Cottam Solar Project

Schedule of Changes (Deadline 2)

PINS Reference: EN010133
Document Reference: EX1/C8.1.7_A
The Infrastructure Planning (Examination Procedure) Rules 2010
Rule 8(1)(k)

Key:

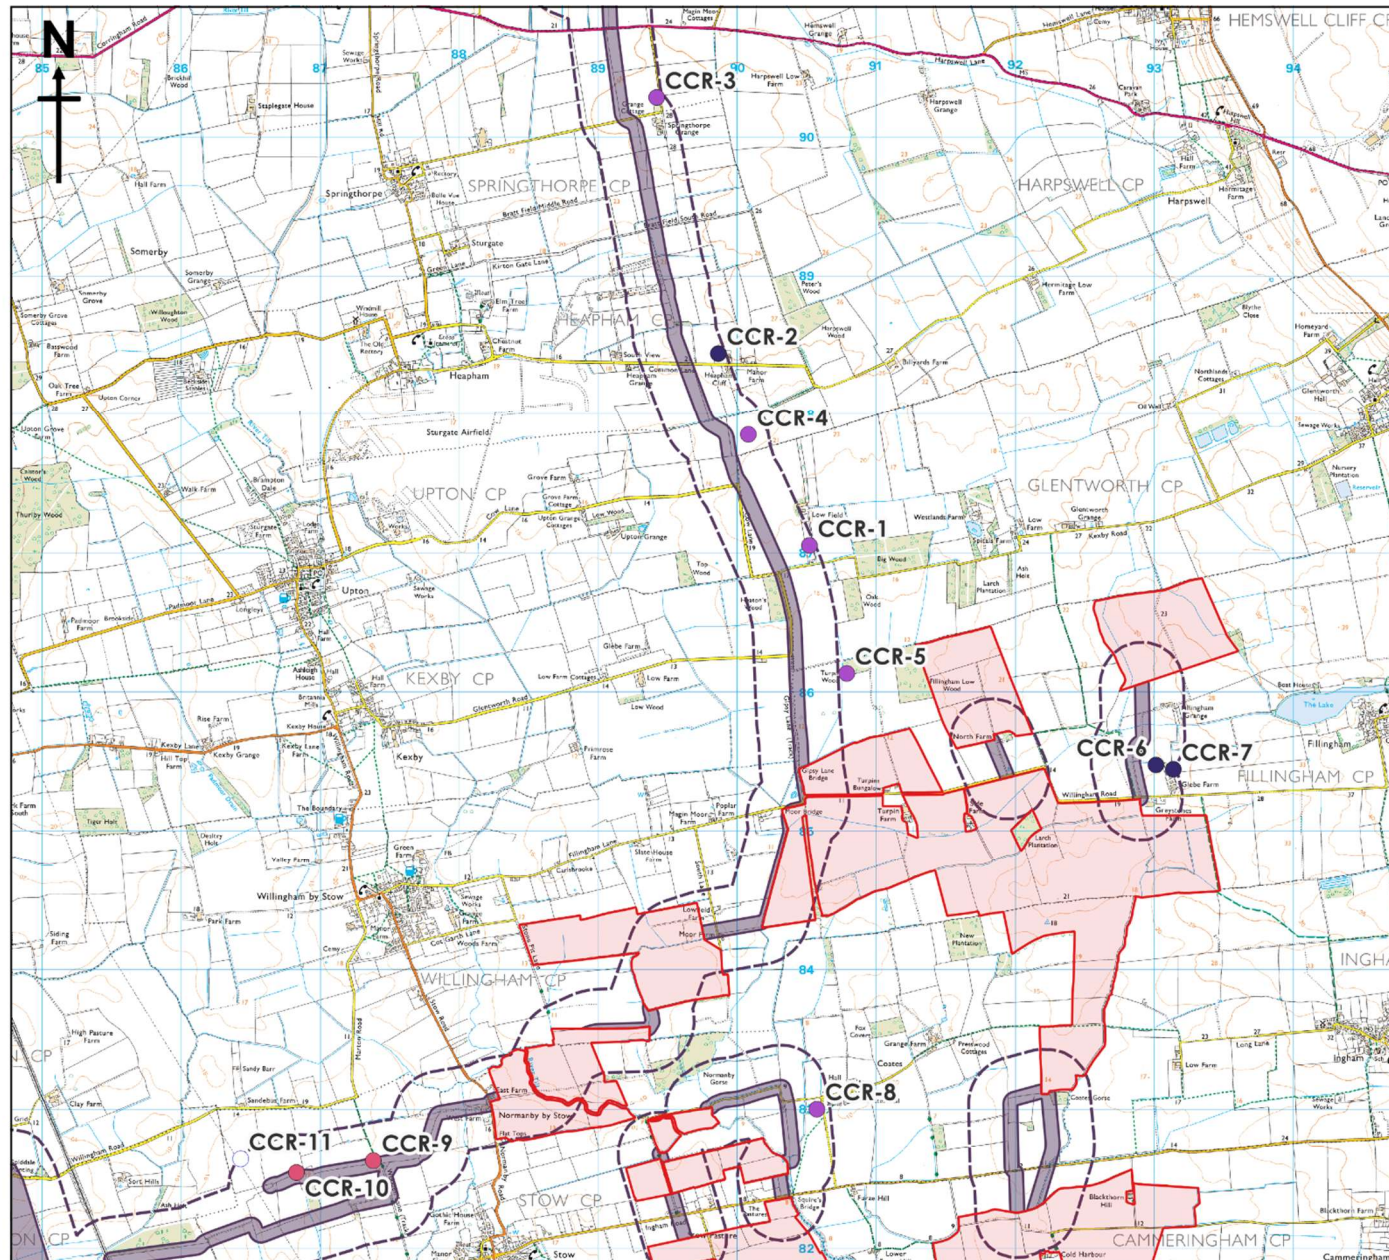
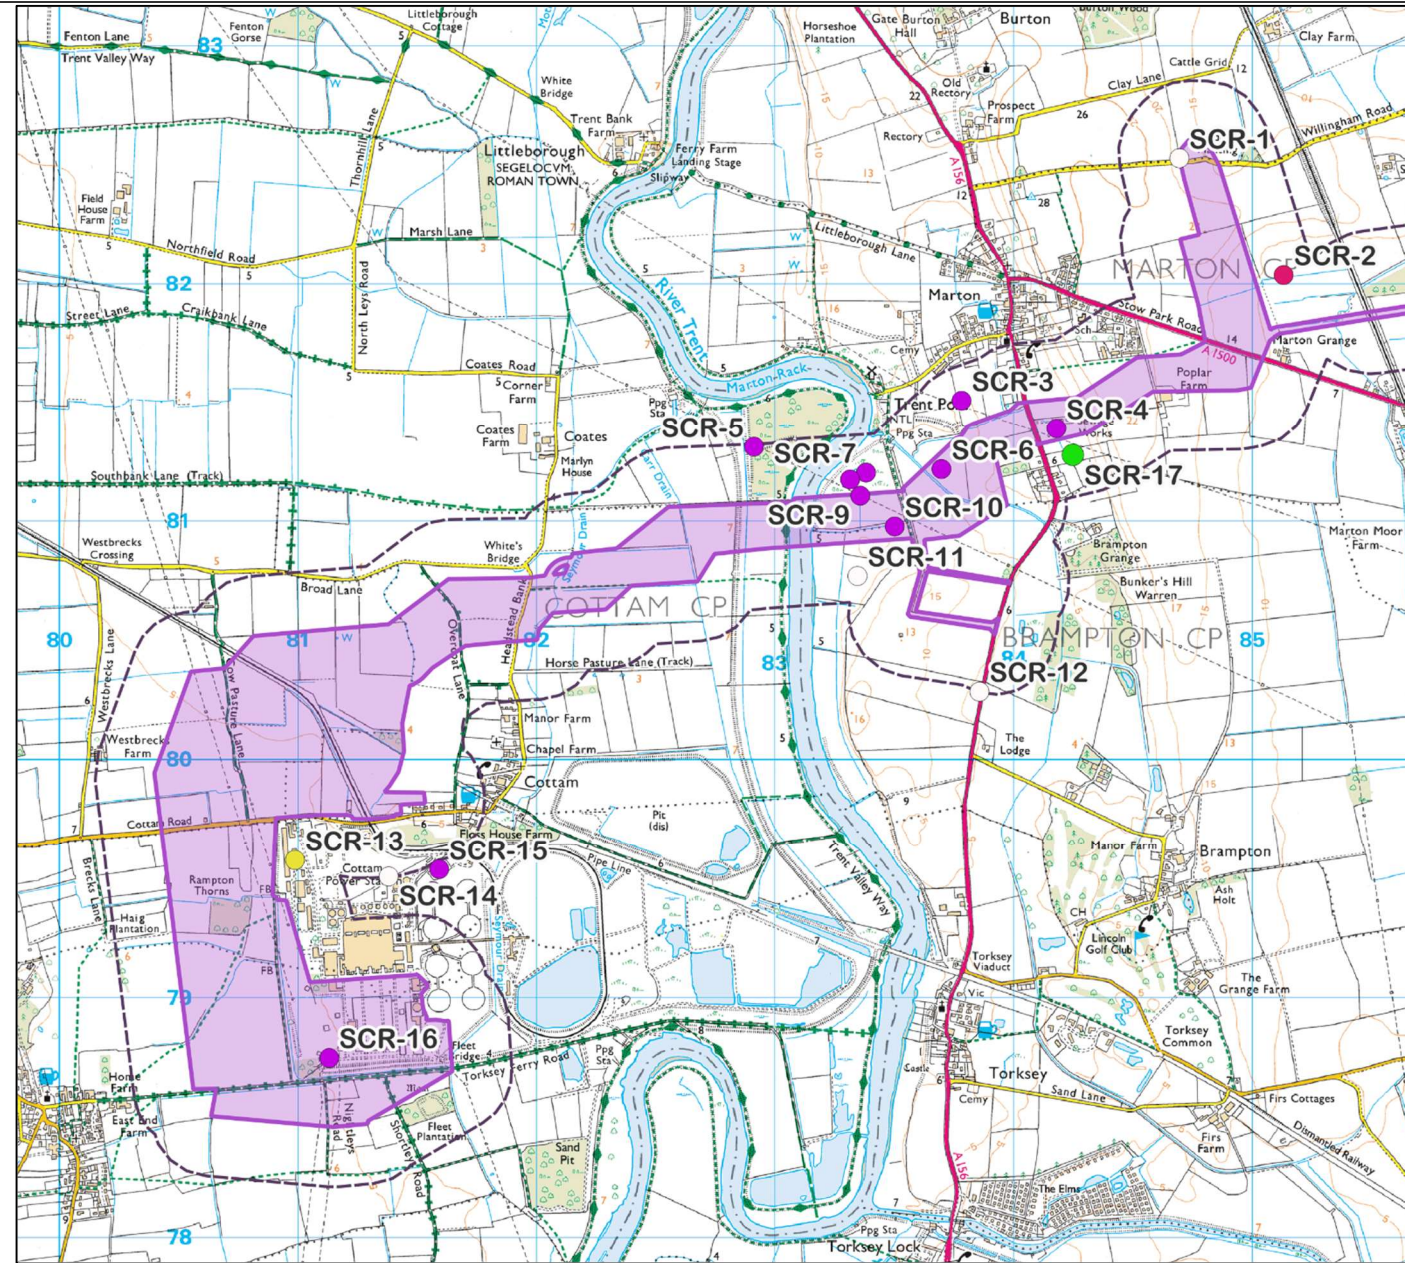
C6.3.9.7 Great Crested Newts Survey Report	[APP-084]	Revision A [EX1/ C6.3.9.7_A]	Deadline 1 17 October 2023	Paragraphs 2.2.11, 4.1.6 and Figure 11, added; Paragraph 2.2.22 deleted and Paragraphs 3.2.6, 4.1.2, 4.1.5, 4.1.7, 4.2.4 and Tables 7, 12 updated to include 2023 Great Crested Newts Survey.	To provide information on the likely presence or likely absence of Great Crested Newts for 6 additional ponds along the cable corridors where access had not been previously arranged and of a further three ponds which were previously found to be dry.
C6.3.14.2 Construction Traffic Management Plan	[APP-135]	Revision A [EX1/ C6.3.14.2_A]	Deadline 1 17 October 2023	Construction Traffic Management Plan updated to take equestrians and reinstatement of private roads into account.	ExA Request ISH1 and to address the British Horse Society's Relevant Representation [RR-023].
